**Reference No:** 2017/62/93430/W

**Site Address:** 11, Foster Avenue, Crosland Moor, Huddersfield, HD4 5LN

**Description:** Erection of single storey rear extension and detached double garage

## Officer Report

client	Mr. K. & Mrs. J. BENSON		
project	PROPOSED EXTENSION TO DWELLING AND CONSTRUCTION OF DOUBLE GARAGE		
address	11 FOSTER AVENUE BEAUMONT PARK HUDDERSFIELD HD4 5LN		
drawing title	ELEVATIONS OF DWELLING AS PROPOSED (sheet 2 of 2)		
scale	prefix	drawing No	rev
1:50 @ A3	2017.16	(KJB) PD 10	A

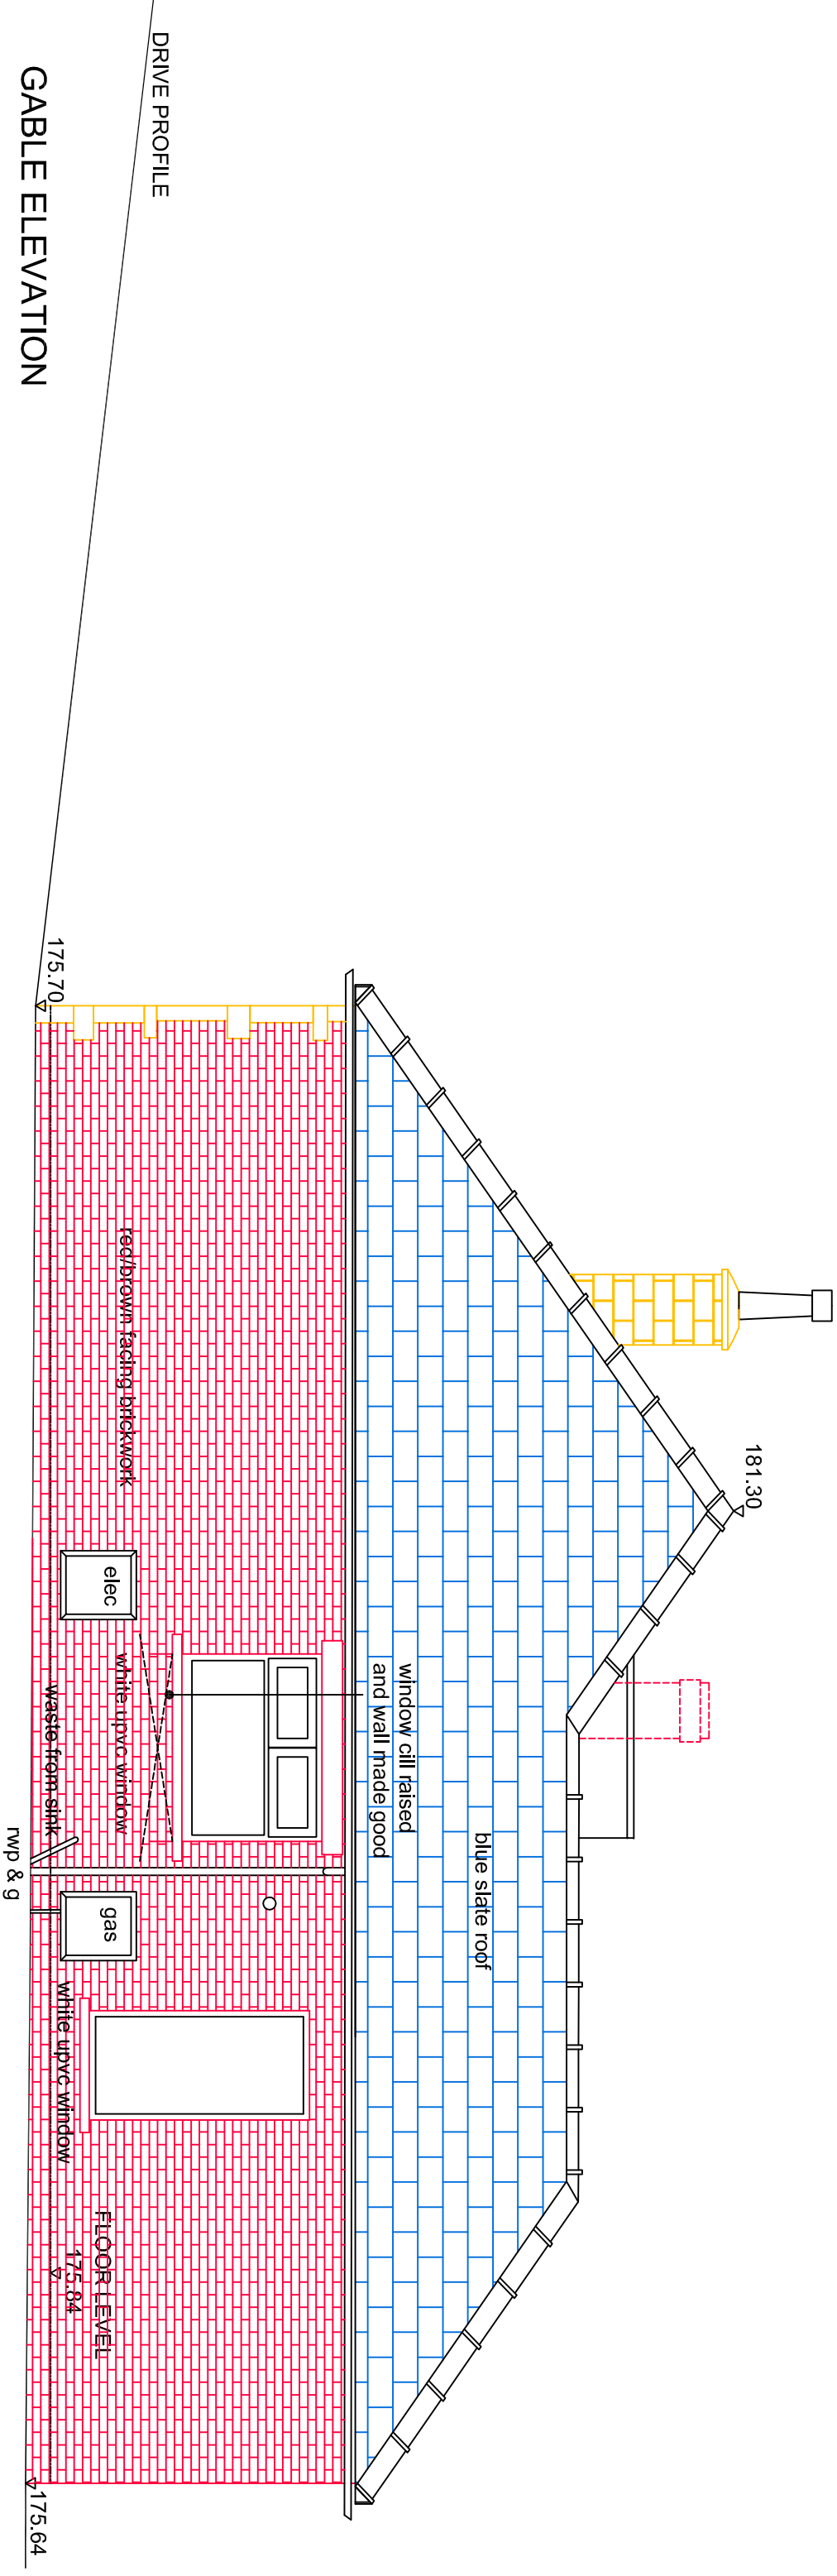
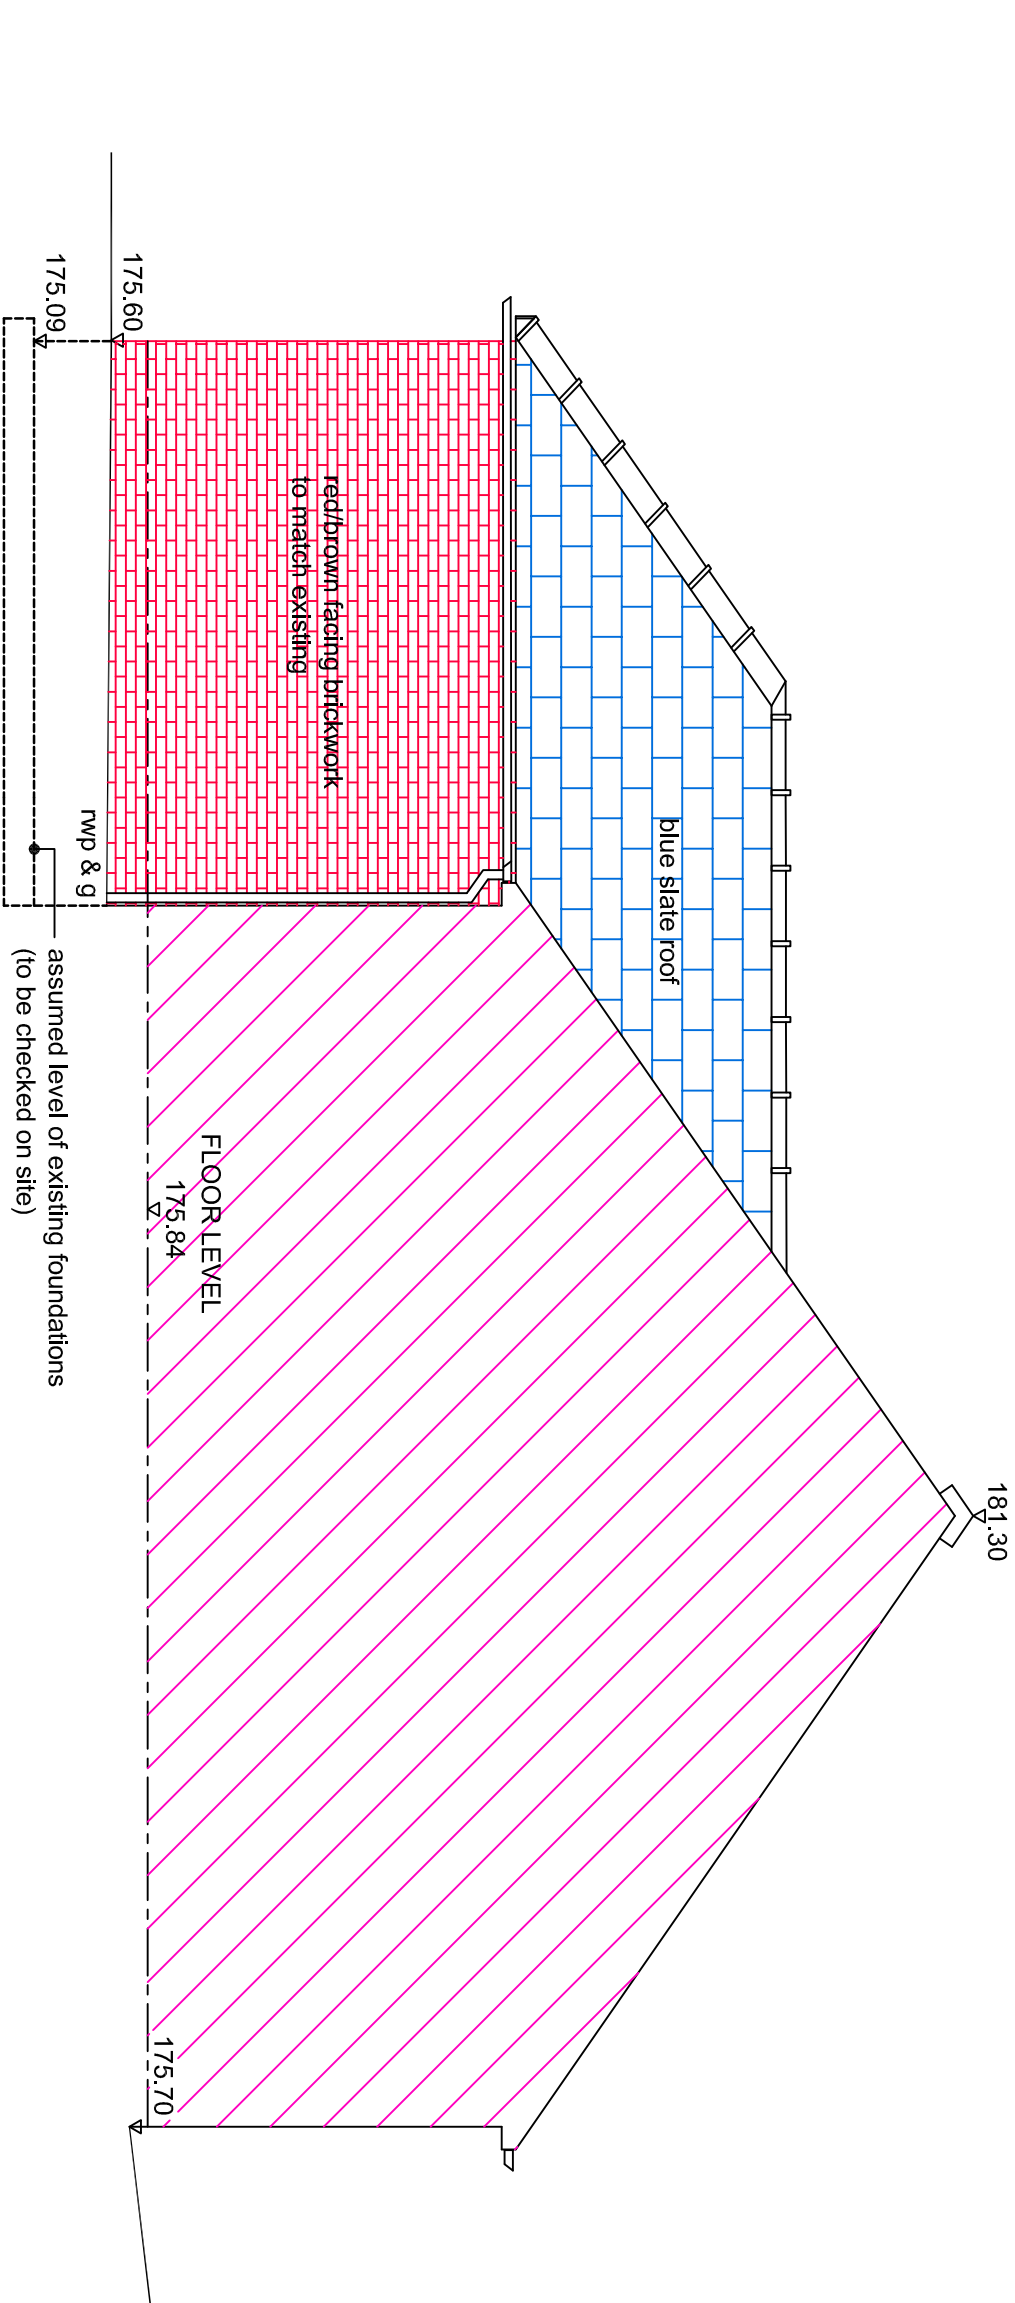
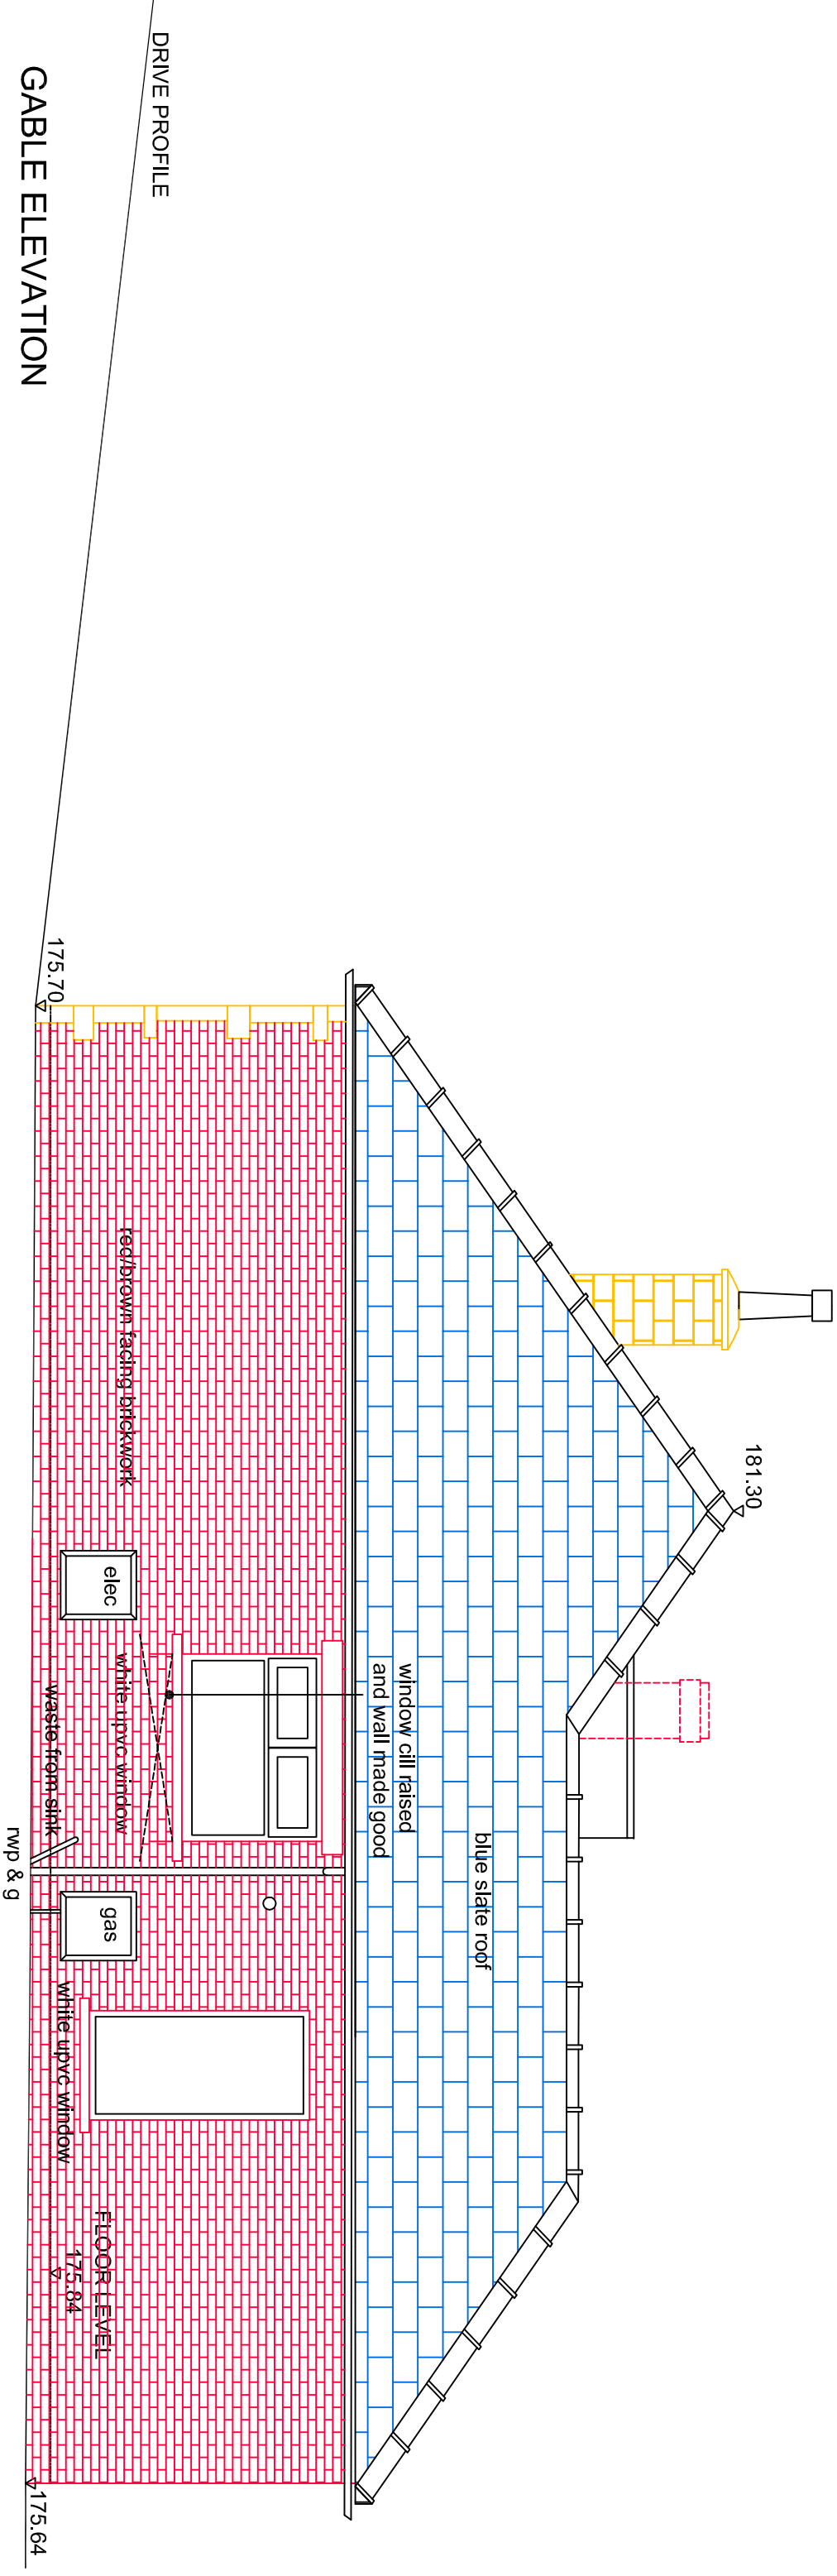
- The structure and materials proposed for this extension will have impact on my residential amenities; loss of light/ overshadowing my property/garden, loss of privacy/ direct overlooking of my property/garden, and creating an oppressive / overbearing environment next to my property/garden.

- The structure and materials proposed for this extension will have impact on my residential amenities; loss of light/ overshadowing my property/garden, loss of privacy/ direct overlooking of my property/garden, and creating an oppressive / overbearing environment next to my property/garden.

**Response:** Amendments have been sought to change the proposed bi-folding doors on the side elevation to a blank elevation wall to prevent any overlooking of no.9 Foster Avenues' private amenity space.
